42 HONEYSUCKLE DRIVE COTTAGE CREEK PRECINCT NEWCASTLE

NEWCASTLE CITY COUNCIL
DEVELOPMENT APPLICATION

ARCHITECTURAL DESIGN RESPONSES

MAY 2018
REV B

9 AM Winter Solstice

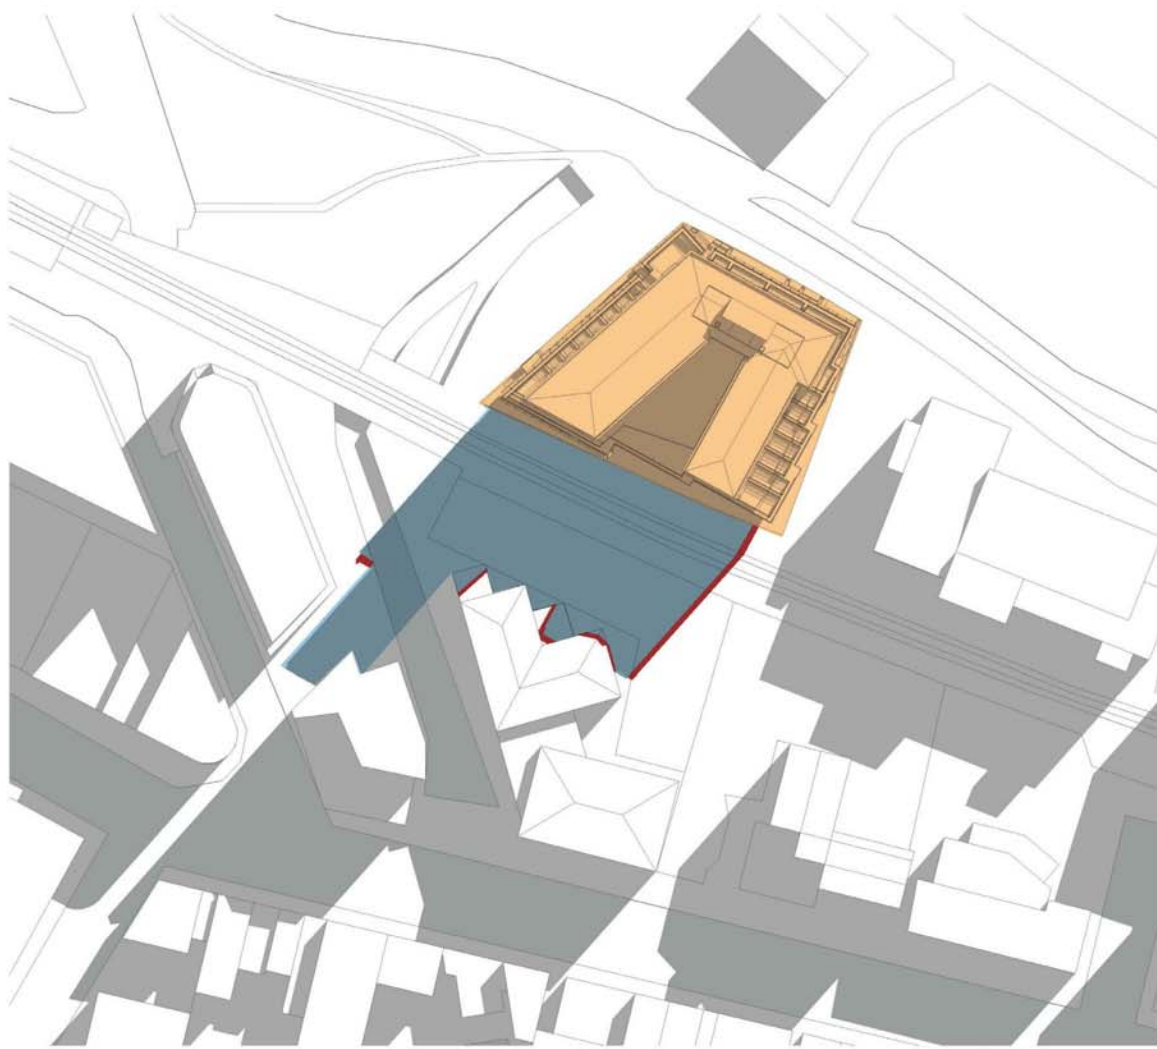
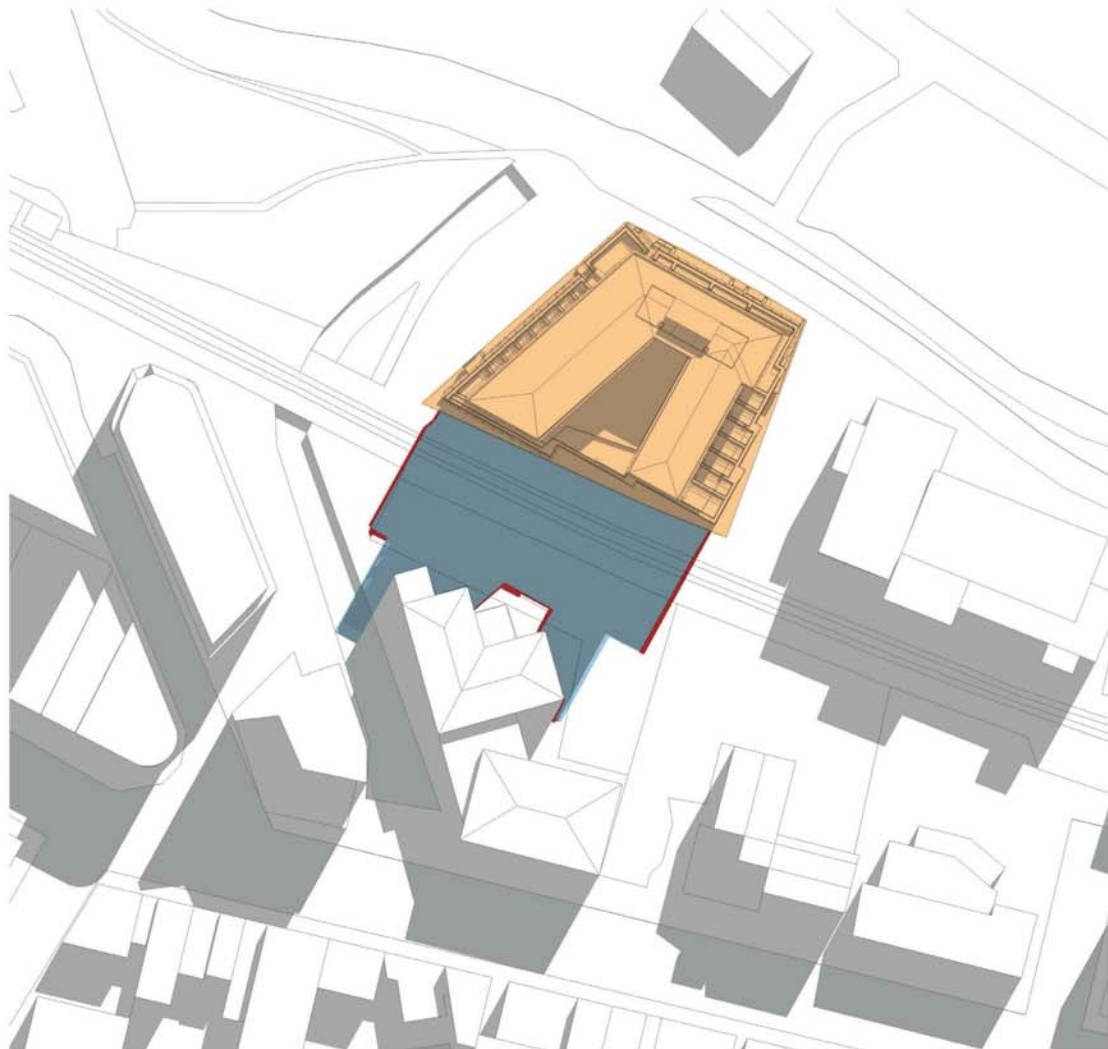
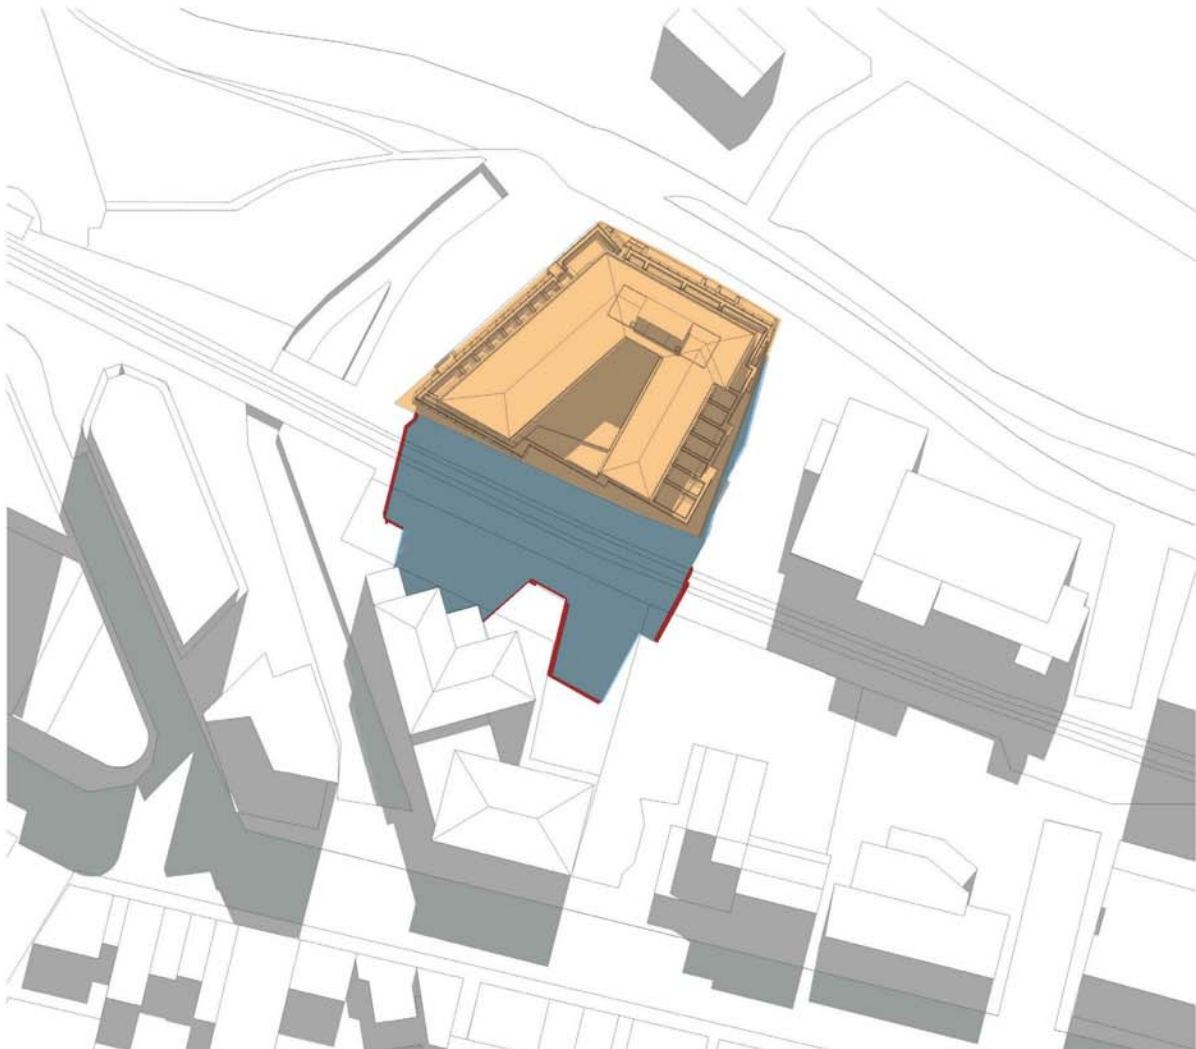
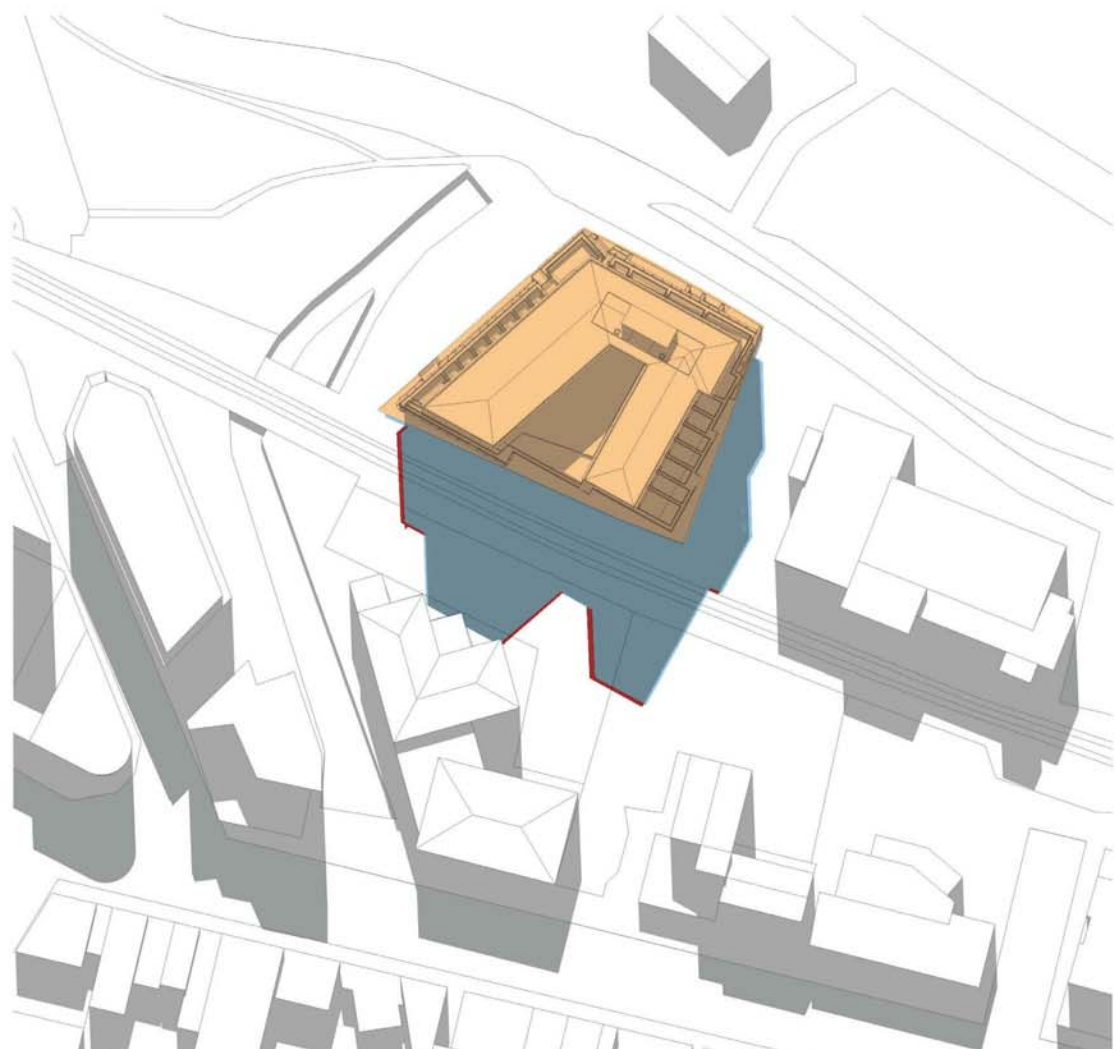
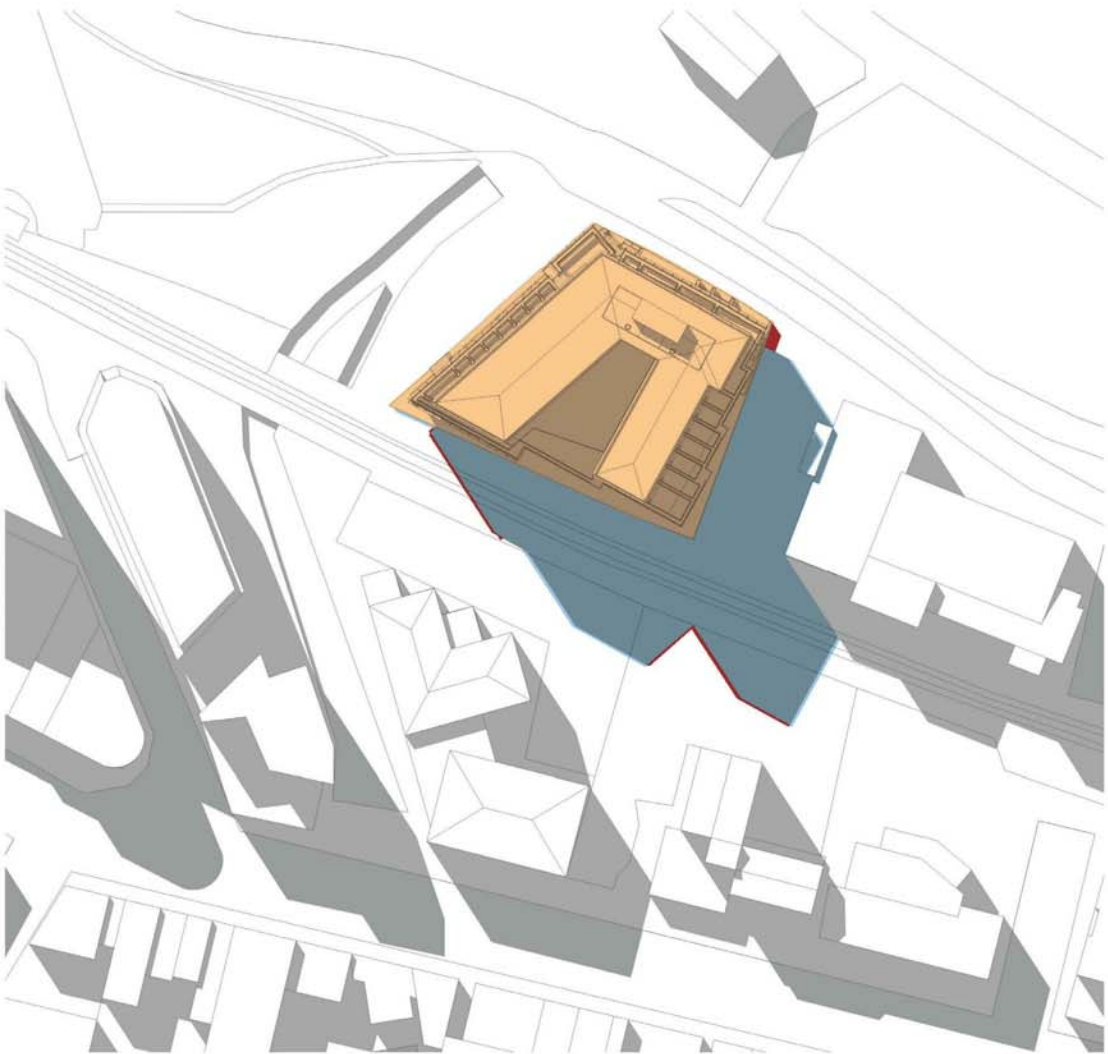
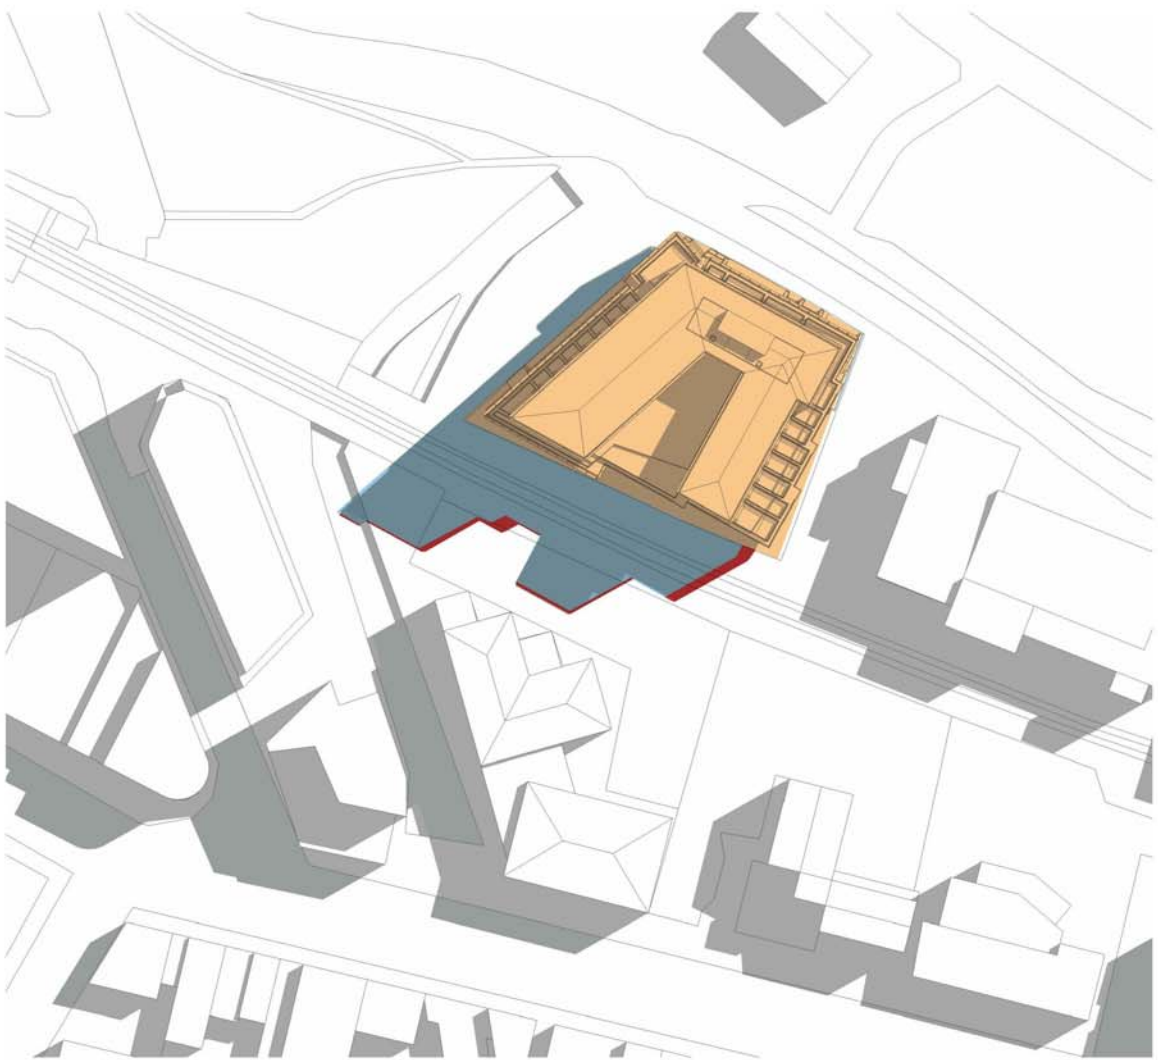
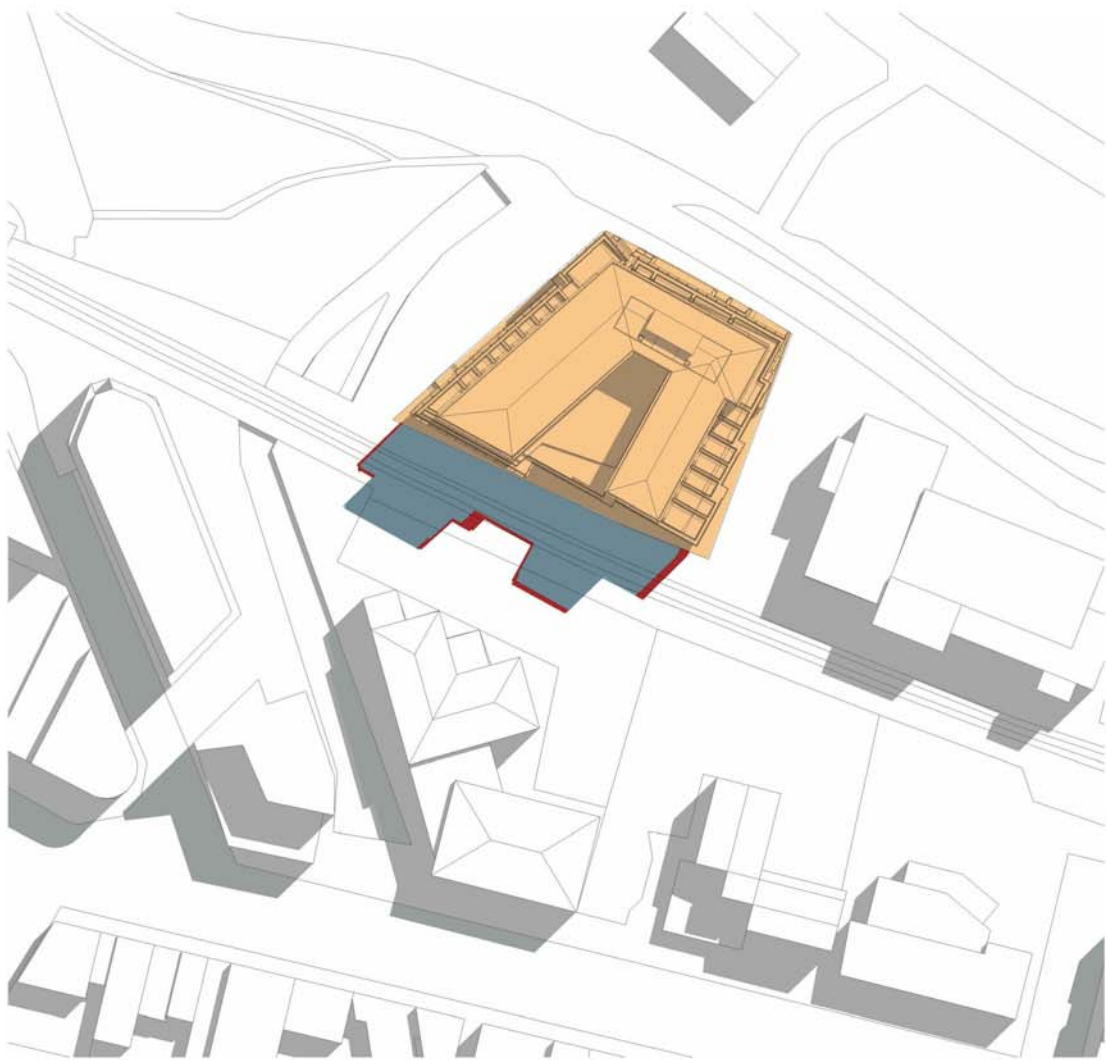
‘Provide revised overshadowing diagrams which clearly show a comparison between the proposed portions of the building which exceed the 30m height standard and a fully compliant building’

See the revised overshadowing diagrams illustrating the comparison between the 30m height standard and the current building form in both the winter solstice and the equinox.

It can be seen that the additional height has very little difference in the extended shadow due to the extra height being placed within the centre of the roof plan across the northern face. With varying permissible heights from neighbouring buildings ensures that the building maintains a presence and prominent address without affecting greatly the green belt and pedestrian connection from the light rail to the waterfront.
